WRITTEN REPRESENTATION

East Pye Solar — Planning Inspectorate Reference EN0110014

To: The Examining Authority, The Planning Inspectorate

Submitted by: Mr. Alan Graham & Mrs Julie Graham – Interested Parties

Figure 11.6: Likely and Suitable Routes to the Scheme
 Sites 7, 8 and 9
 Revision A

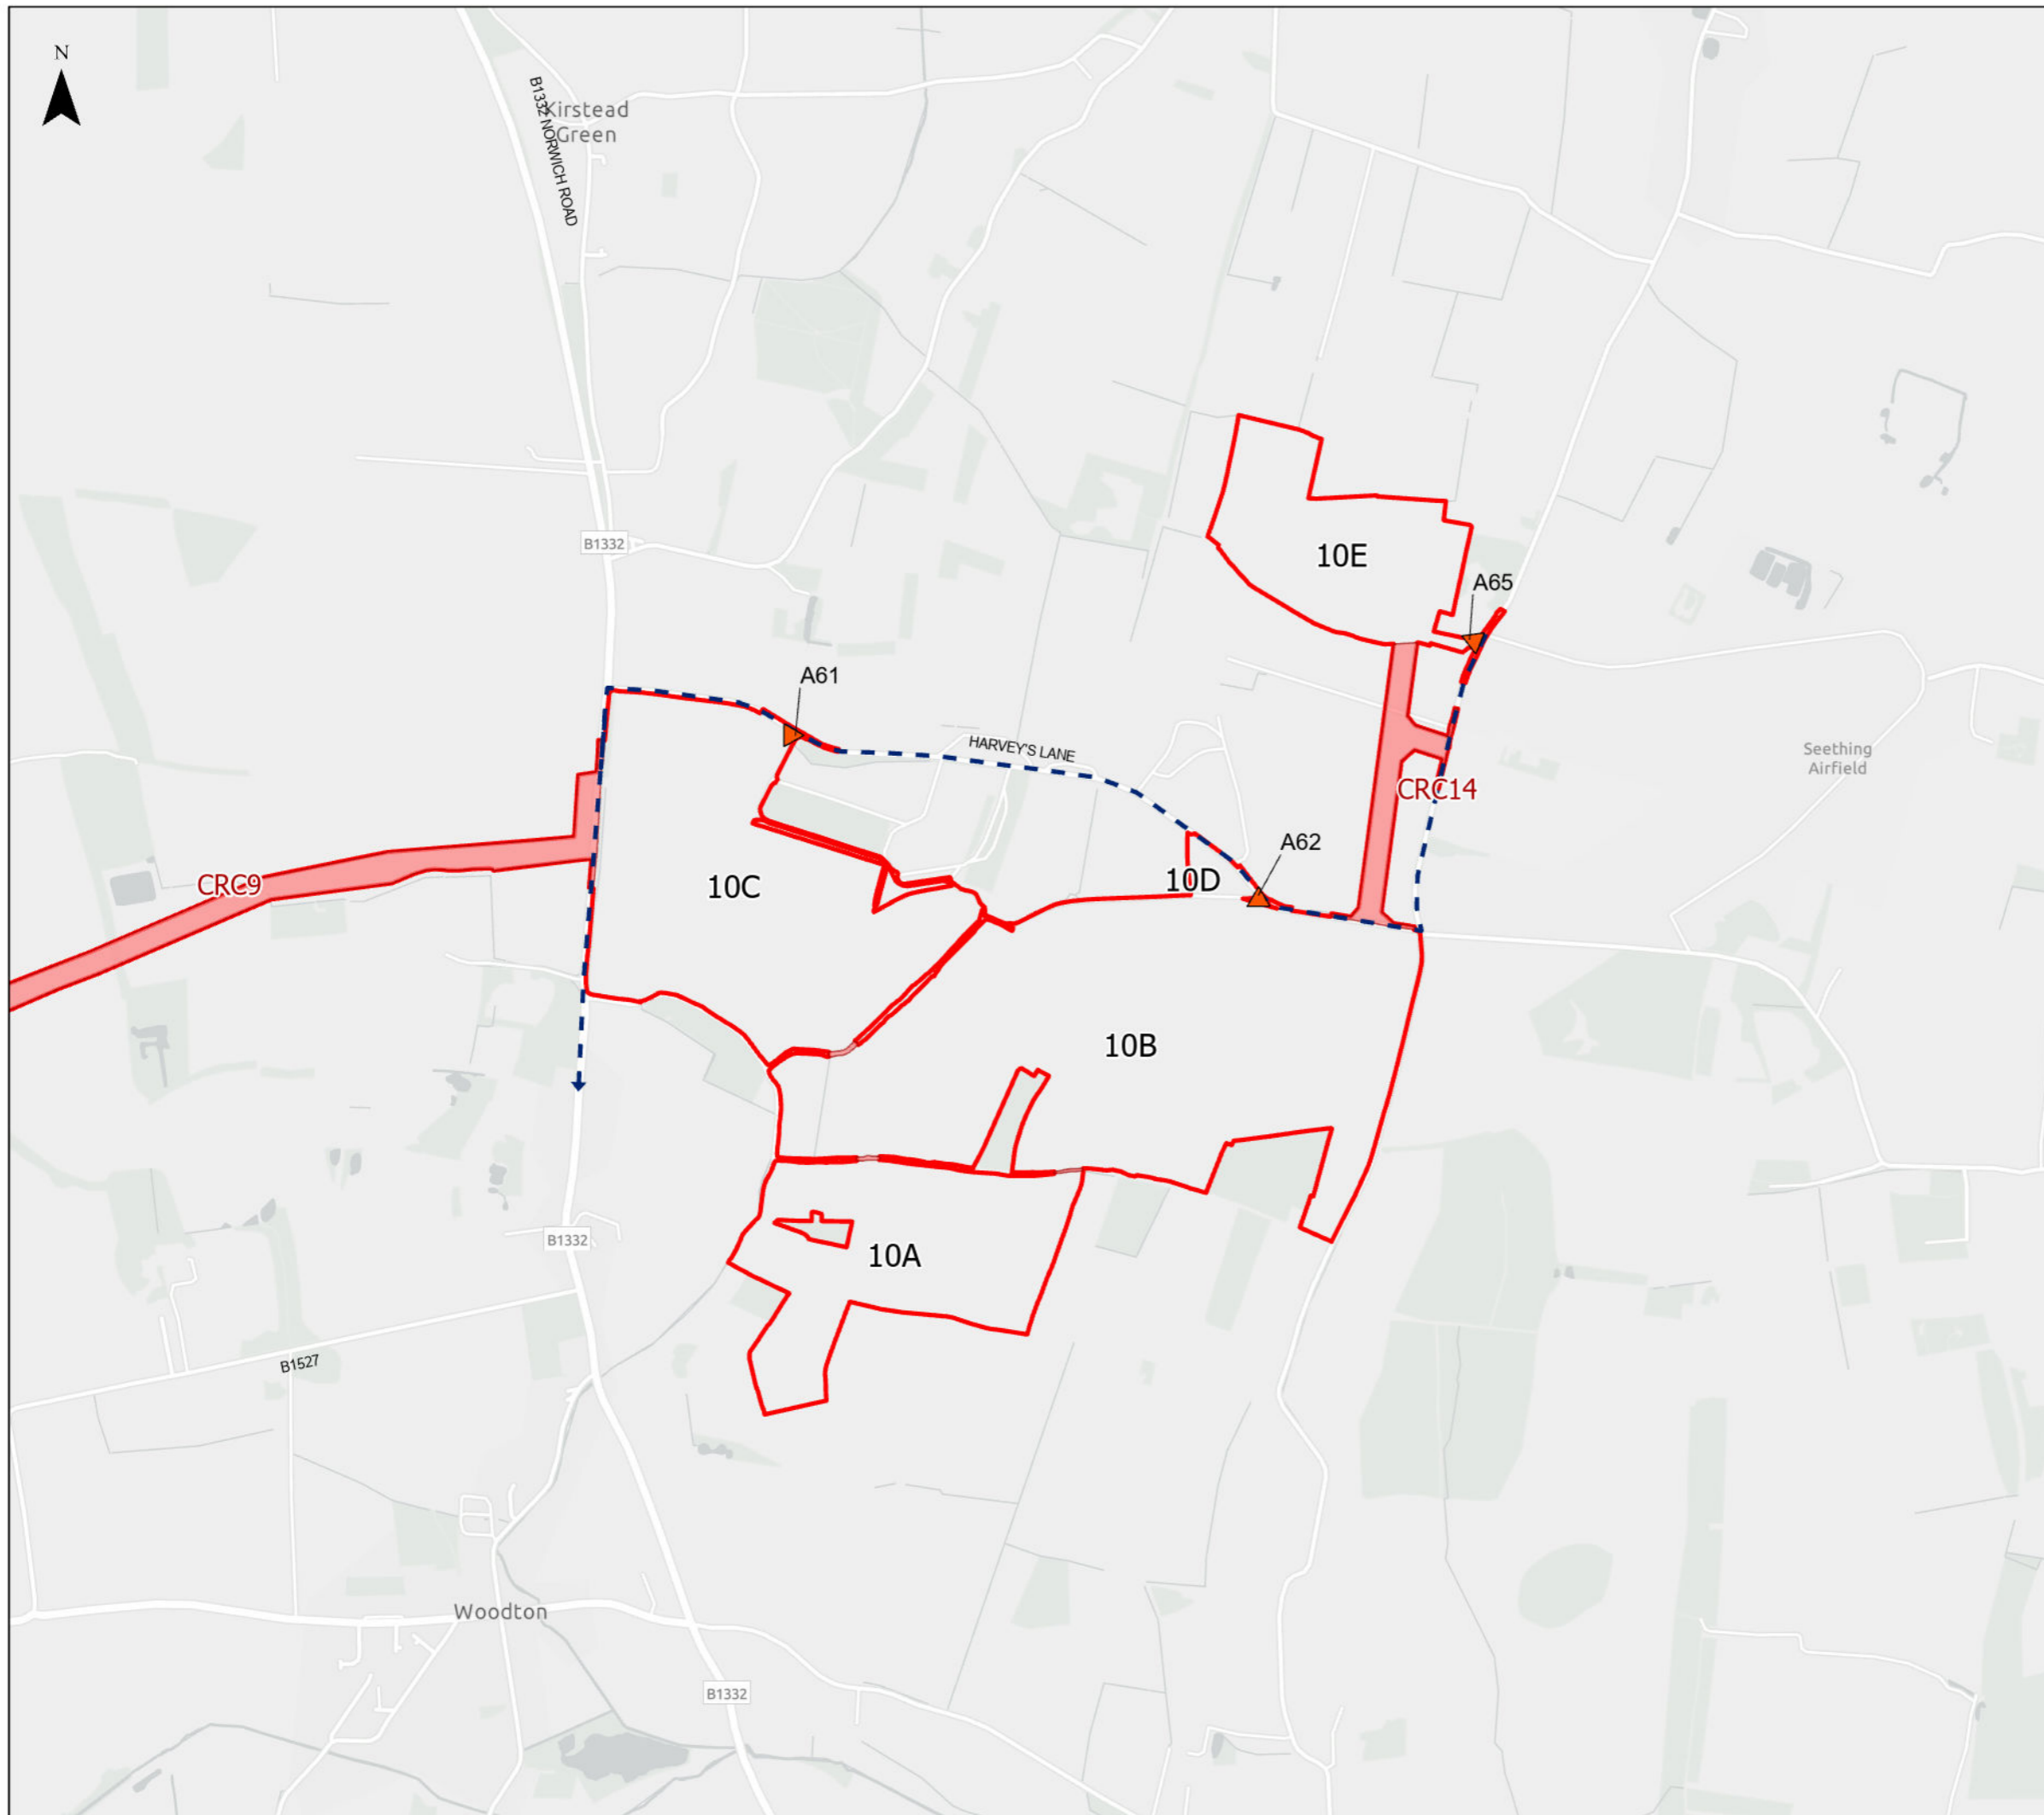
11.1 The Outline Construction Traffic Management Plan (APP/7.6) identifies that Abnormal Indivisible Load (AIL) movements for the transformer serving Sub-Site 7F will be routed via The Street, Saxlingham Nethergate. To accommodate these abnormal loads, which may be up to 5.5 metres wide, the 4.5 metre-wide street through the village would need to be widened.

11.2 The proposed widening would require the demolition of an 18th century wall at the Old Rectory and the expansion of the carriageway onto part of the triangular parcel of land on which Saxlingham Nethergate's Grade II listed war memorial stands. This is an extraordinary and wholly unacceptable proposal.

11.5 We request that the Examining Authority requires the Applicant to demonstrate that no viable alternative AIL route exists that avoids The Street in Saxlingham Nethergate and eliminates harm to the Grade II listed war memorial and the 18th century wall at the Old Rectory.

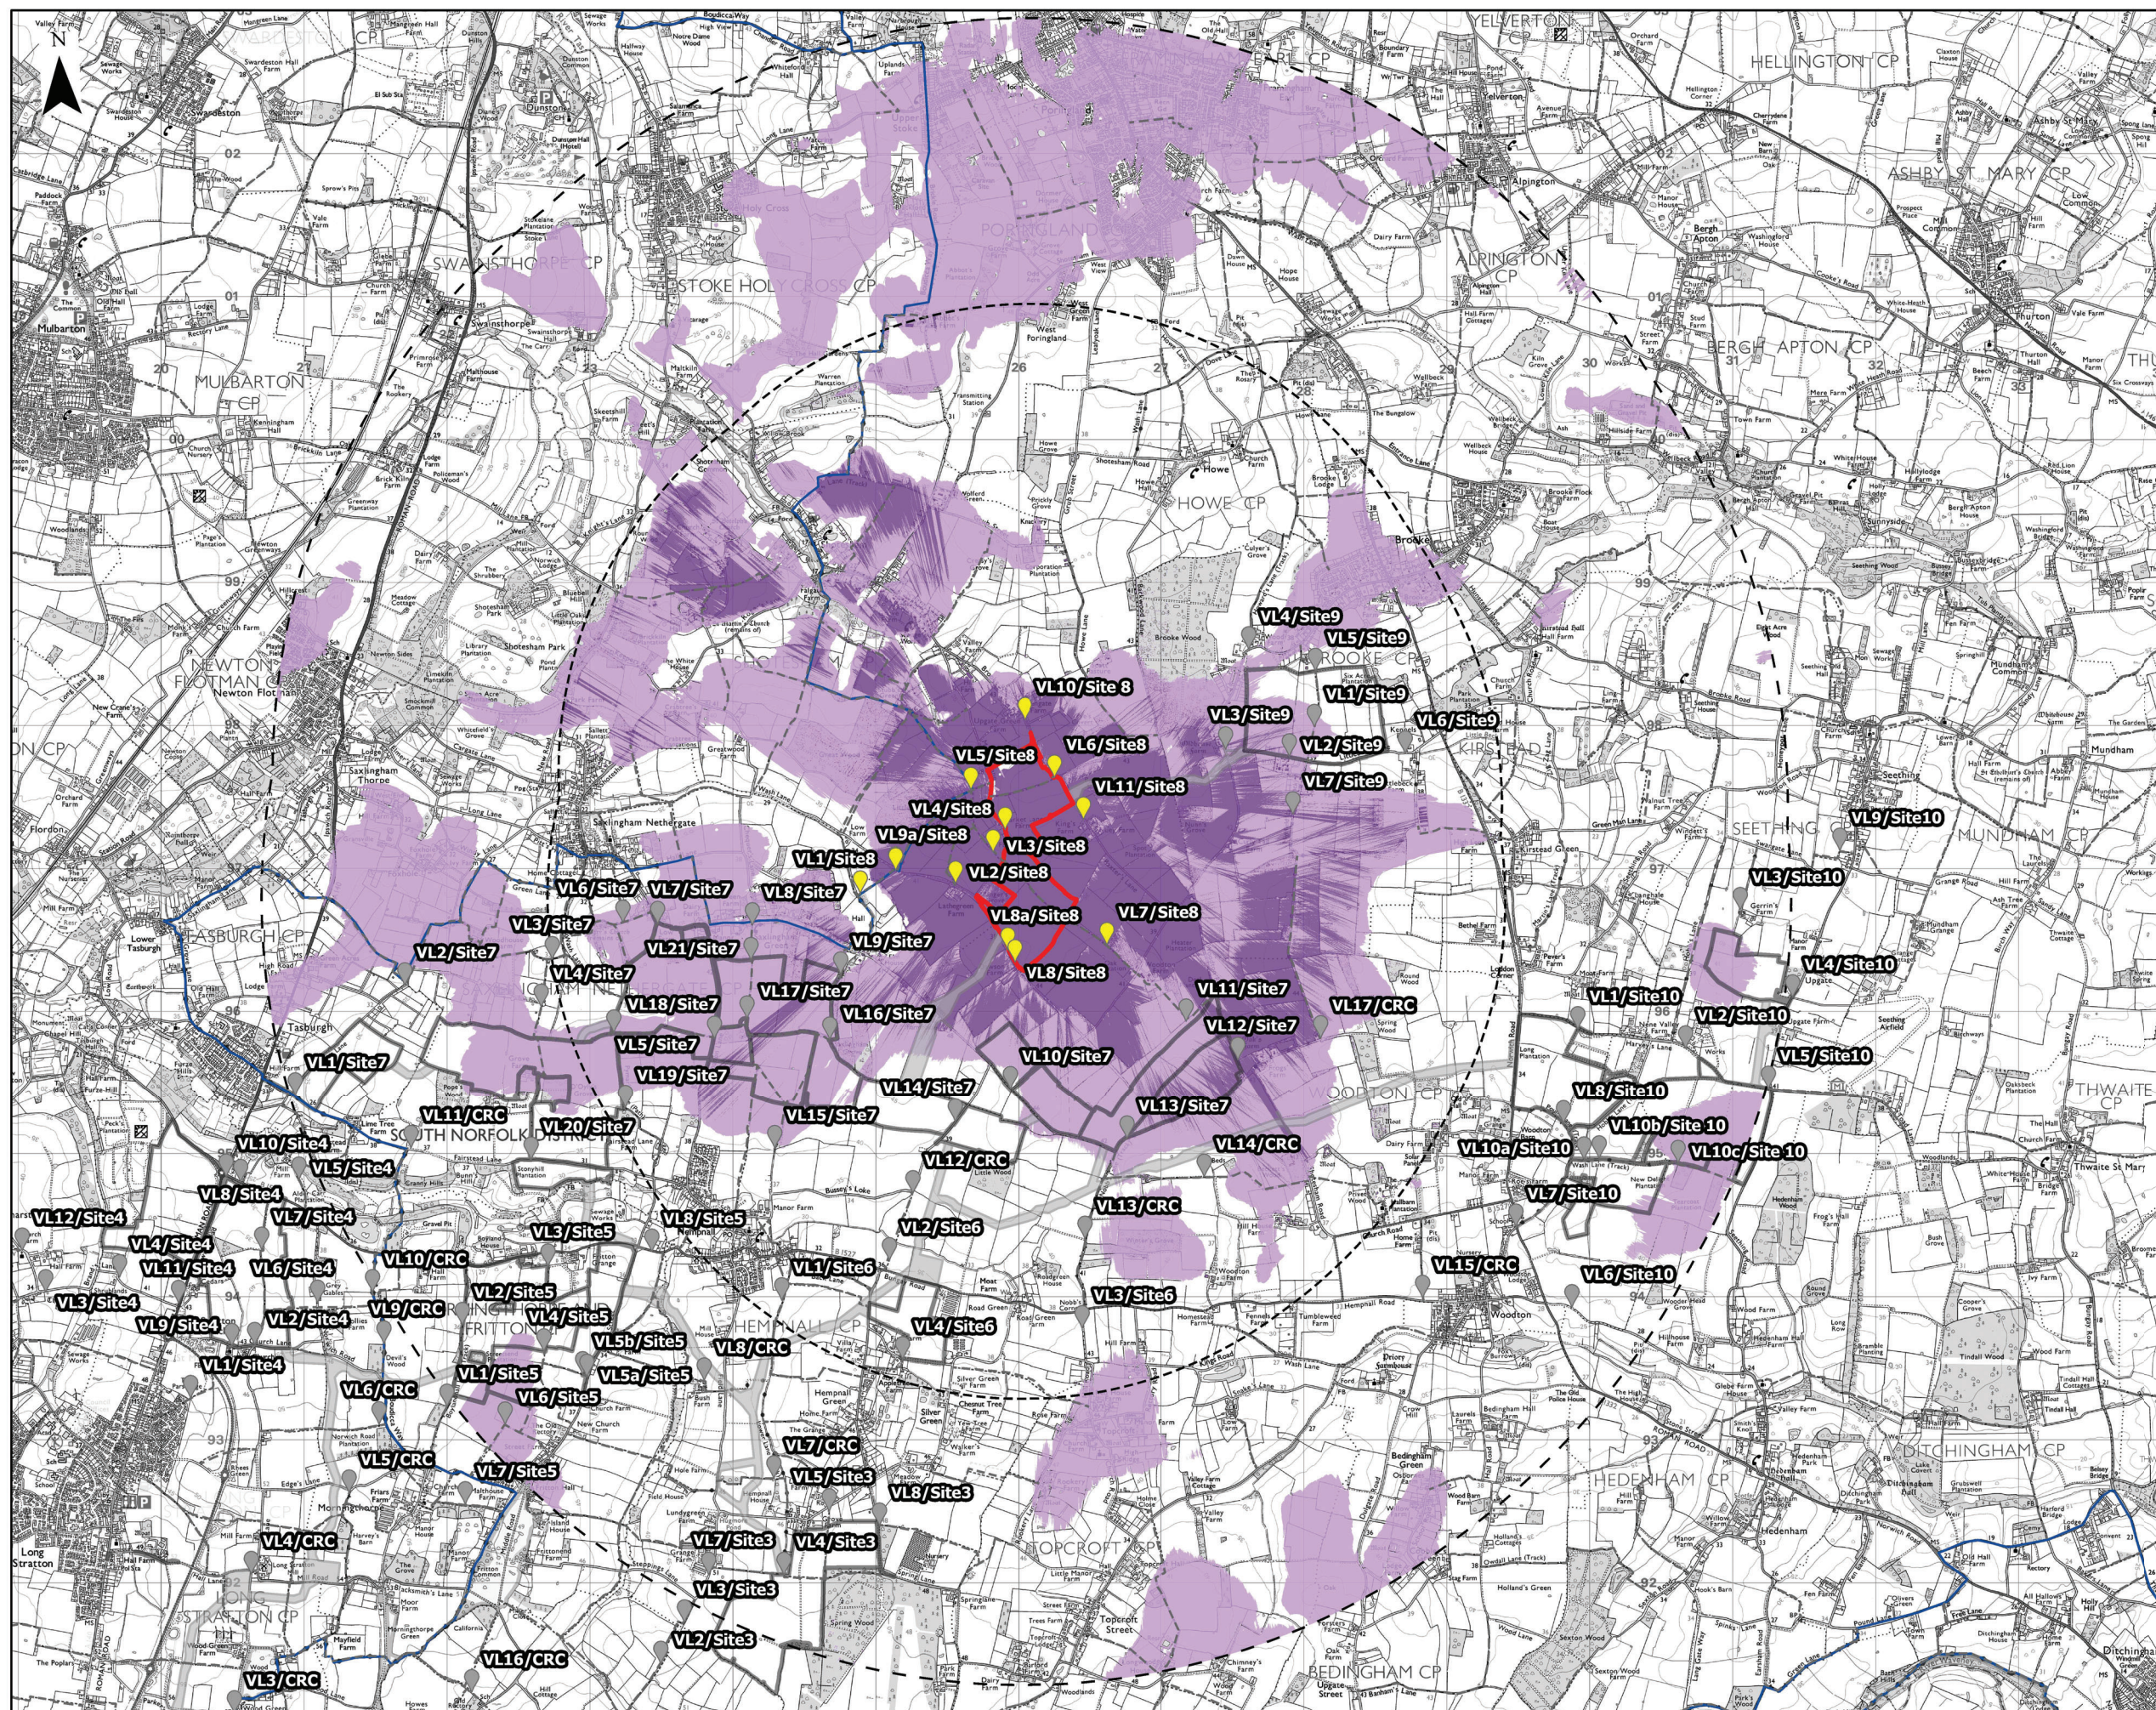
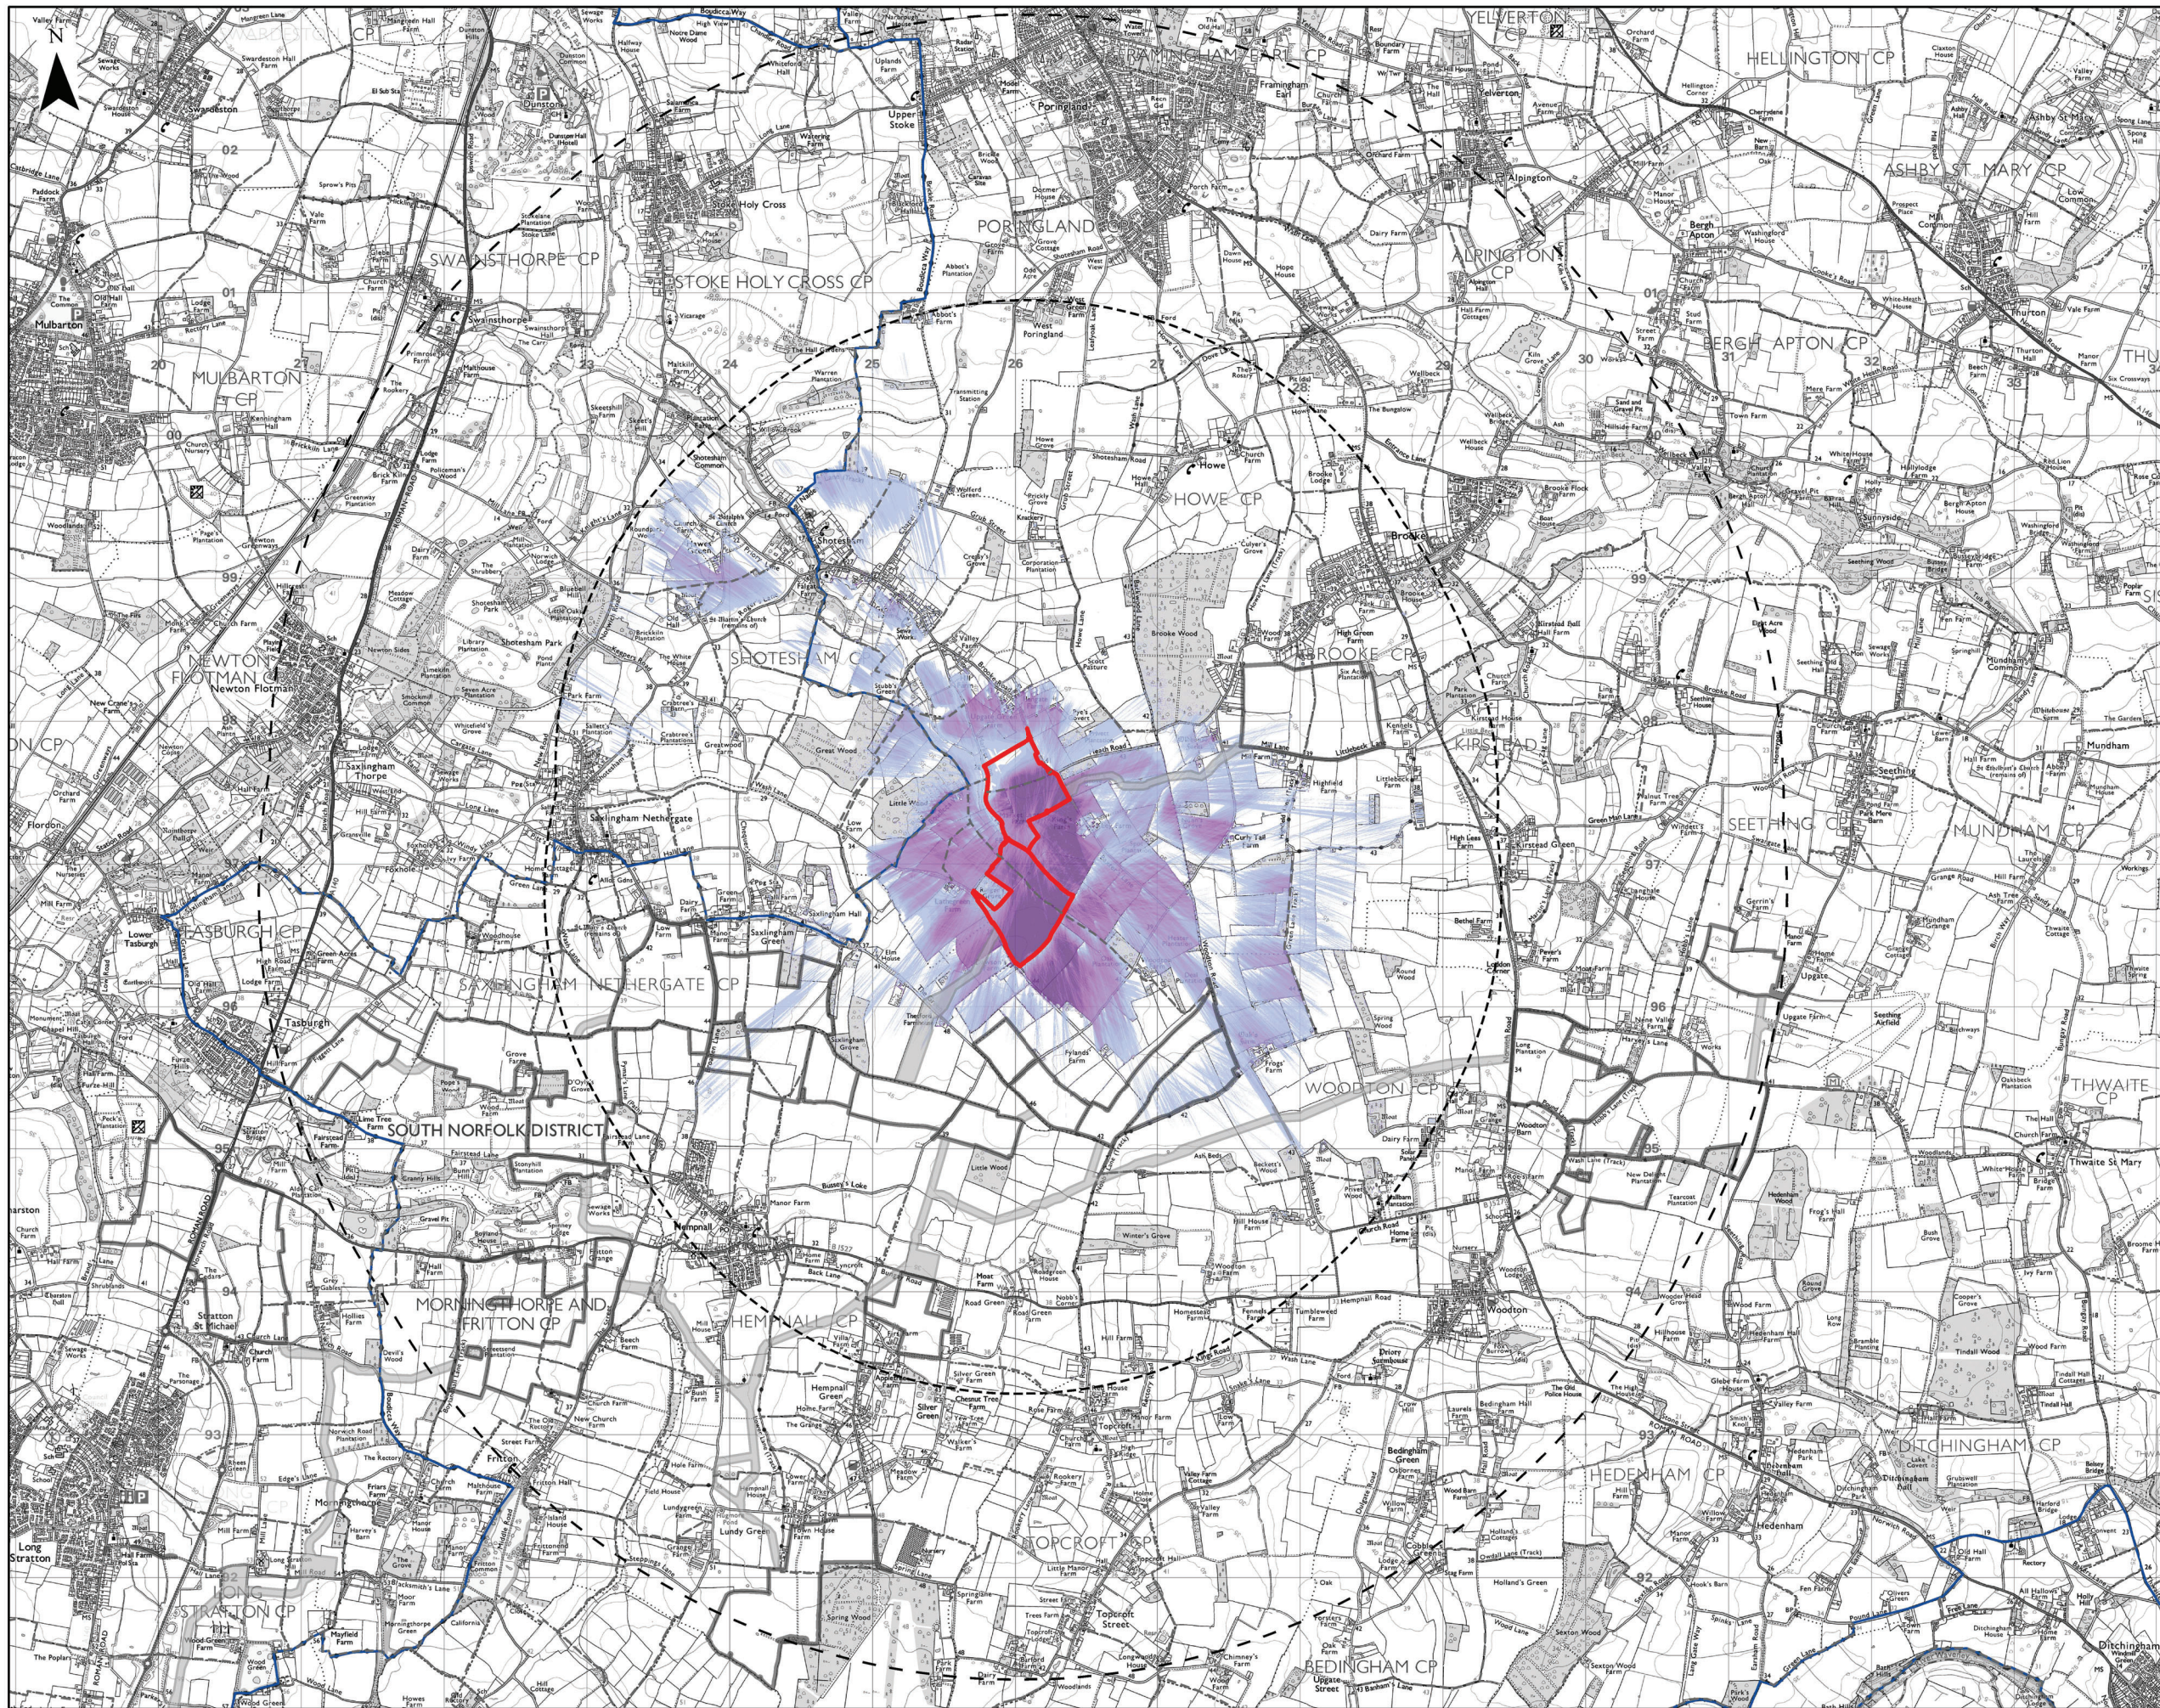
- (a) Requires the Applicant to confirm whether the Property at Hawes Green falls within the ZTV for Sites 7 (Figure 7.5.5) and 8 (Figure 7.5.4), and if so to explain why it has not been assessed as a named residential receptor viewpoint in the LVIA, given that paragraph 7.5.22 of ES Chapter 7 identifies Shotesham as a settlement from which visual effects are likely;
